PLANNING BOARD

October 29th, 2015

Project Name: Subdivision and Change of Use/Renovation of existing building to create Ten Residential Units
Project #: #2015-162; Level III Subdivision and Site Plan
Address: 415 Cumberland Avenue, Portland
CBL: 036 G033 001
Applicant: Patrick Ducas
Planner: Jean Fraser

415 Cumberland Avenue
Book 30443 Page 133
(from CCRD)
Site Plan Key
Parcel = 0.14 acres = 6,098 s.f.
Footprint: 4,999 s.f.
Floor Area: 15,708 s.f.
Easement: 525 s.f.
First floor Elev. 85.89

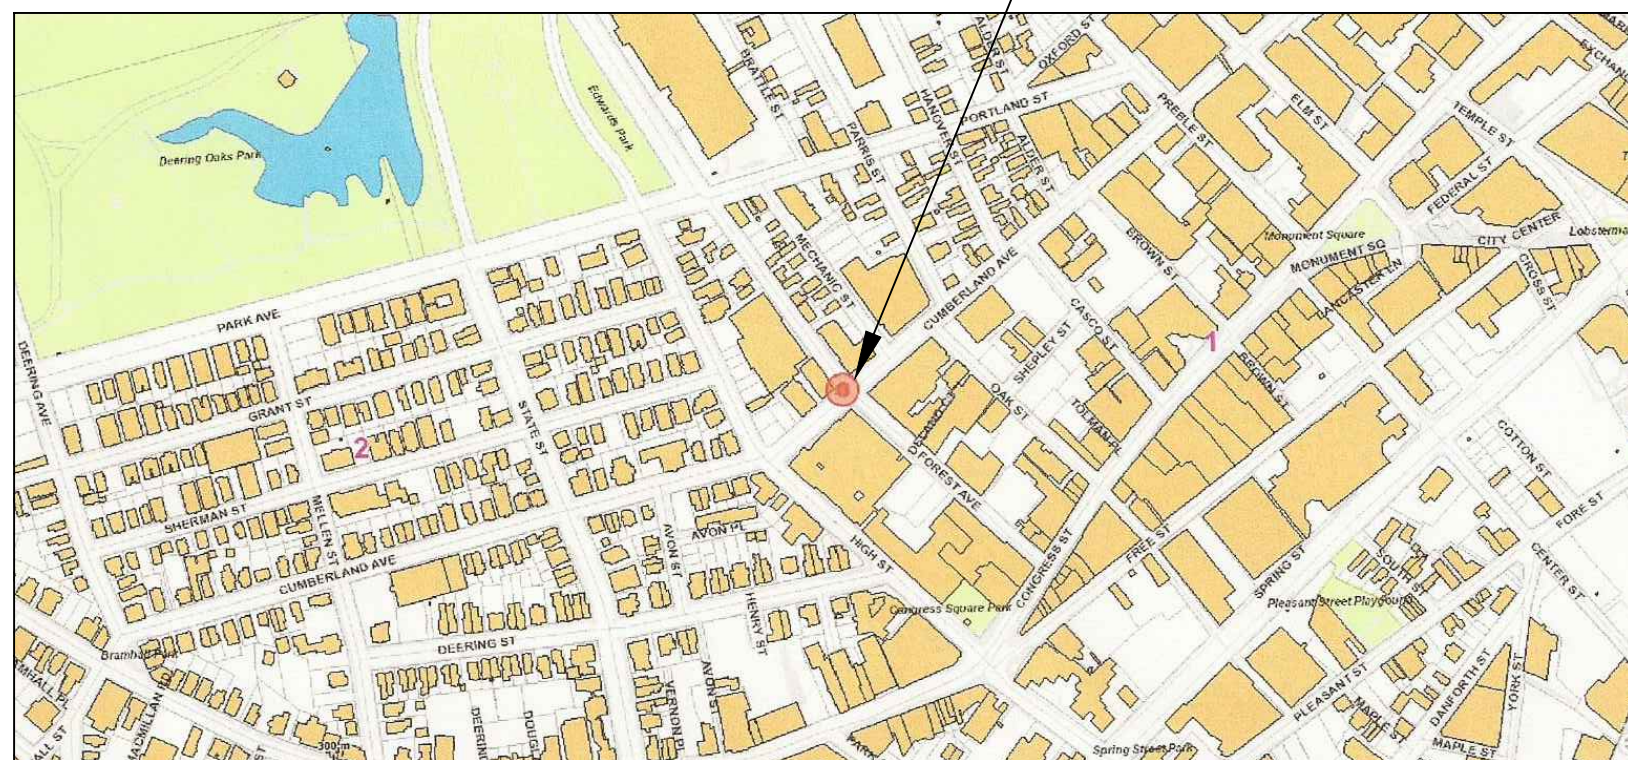
- i. That the applicant shall submit a revised site plan/plat that shows the location and design of the 4 bicycle parking spaces, the proposed planting in the front garden area including 2 street trees on the site, and the replacement ADA ramp panel in the ROW at the corner of Forest Avenue and Cumberland Avenue (to meet the City's Technical Standards for any work in the ROW), for review and approval by the Planning Authority prior to the issuance of a building permit; and

All requirements have been met. The subdivision plat (Plan P2.) has been reviewed by the Department of Public Services (DPS) Surveyor, the Legal Department and the Fire Department staff (Attachments 1, 4 and 5). The Legal Department and DPS Surveyor have requested clarification regarding the easements and other survey information; the draft plat in Plan P2 will need to be revised to address these comments.

5 Top Roof drainage plan
1/4" = 1'-0"

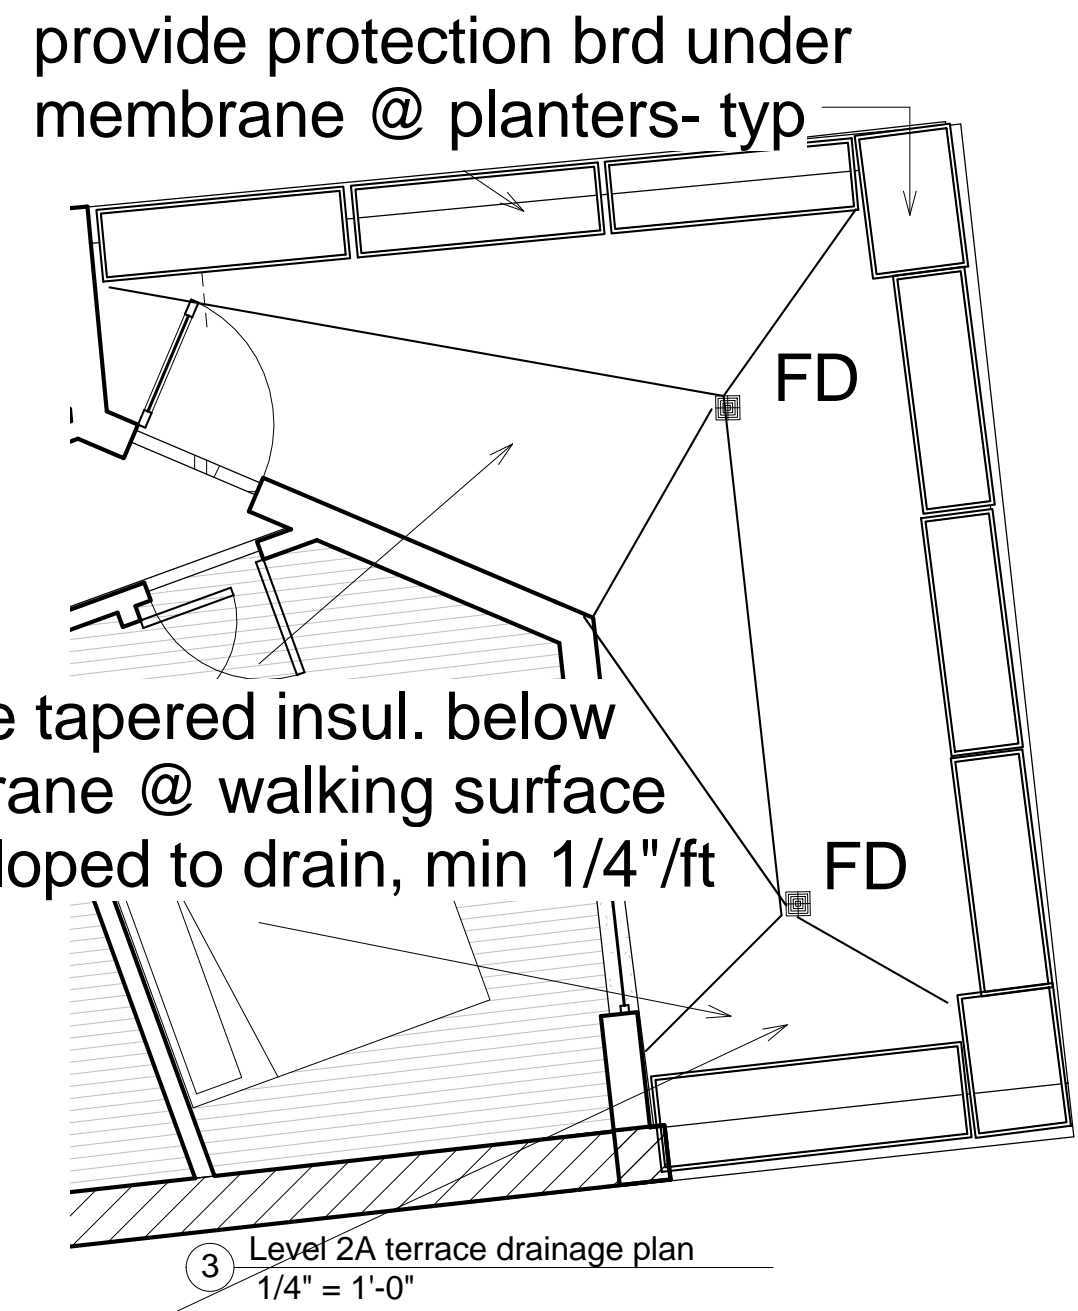
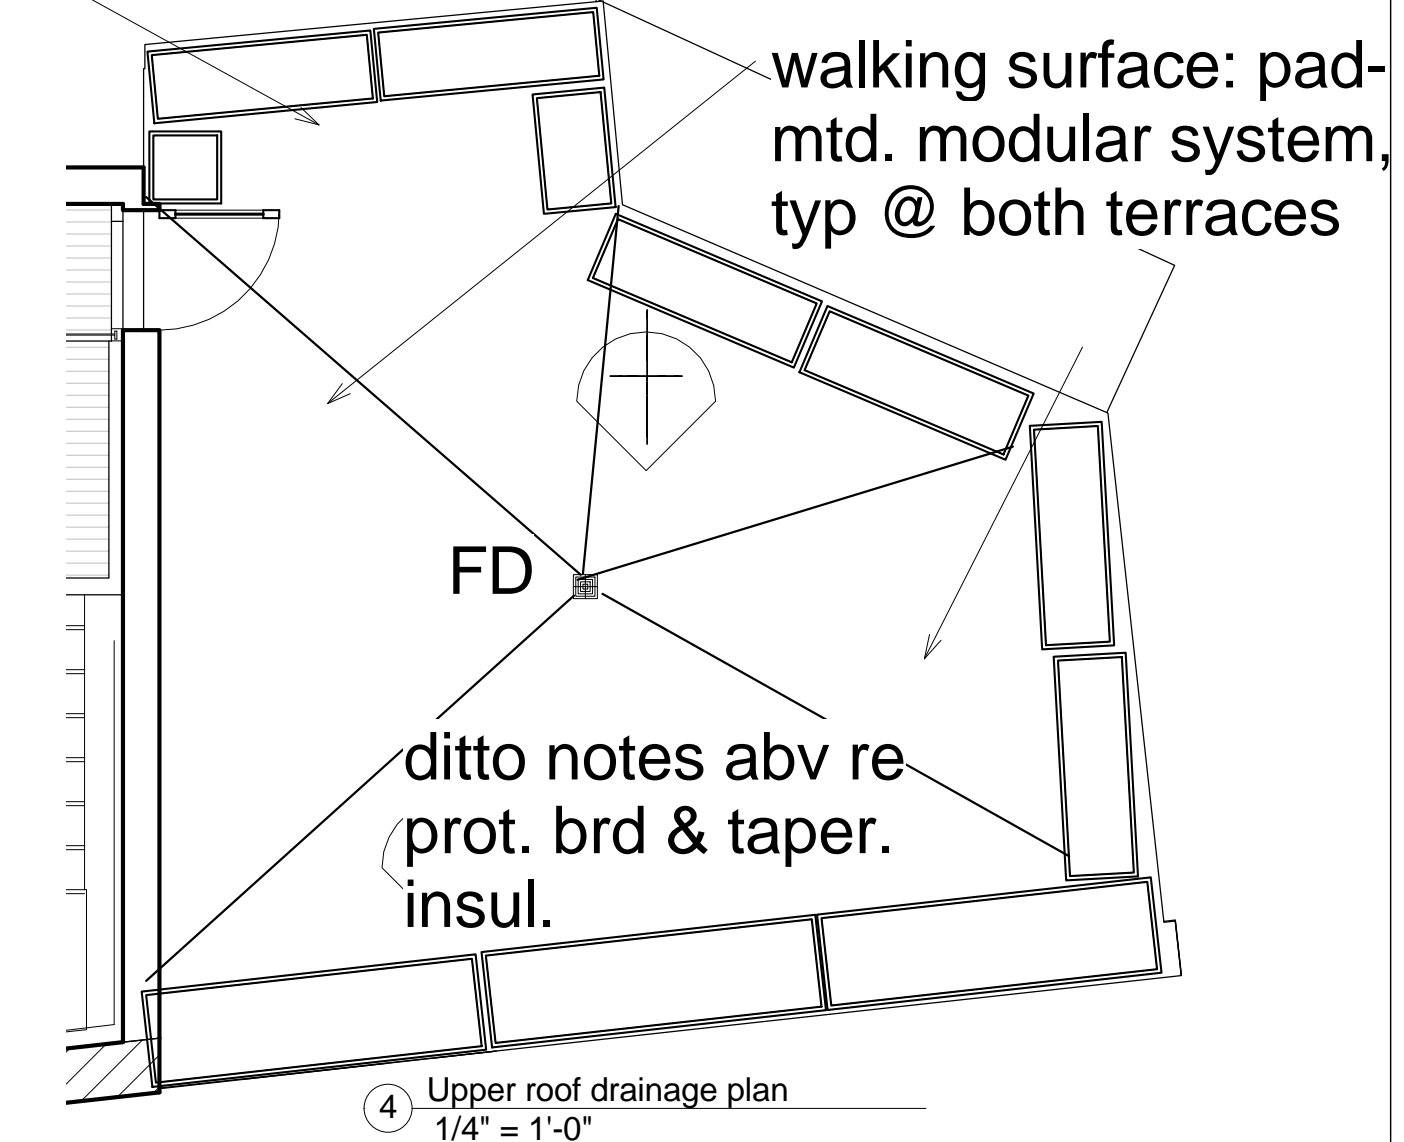
- ii. That the applicant shall submit plans showing the proposals for: A) Any modifications to the roof drainage to meet the Wastewater Capacity Letter conditions (that all roof drainage be directed to the sidewalk or street level); and B) All upgrades to the existing water and sewer utilities at the existing locations, including restoration of the sidewalk (to meet the City's Technical Standards for any work in the ROW); both for review and approval prior to the issuance of a building permit; and

The reuse of the building does not require any upgrading to meet current stormwater requirements, but the DPS in their Wastewater Capacity letter ([Attachment 1](#)) has requested that all rainwater downpipes be directed to the sidewalk or street level and not be connected to the sewer. The applicant is checking on whether a central roof drain is connected to the sewer and the suggested condition requires that if there is a connection that the proposals to redirect that drainage be submitted for review and approval.
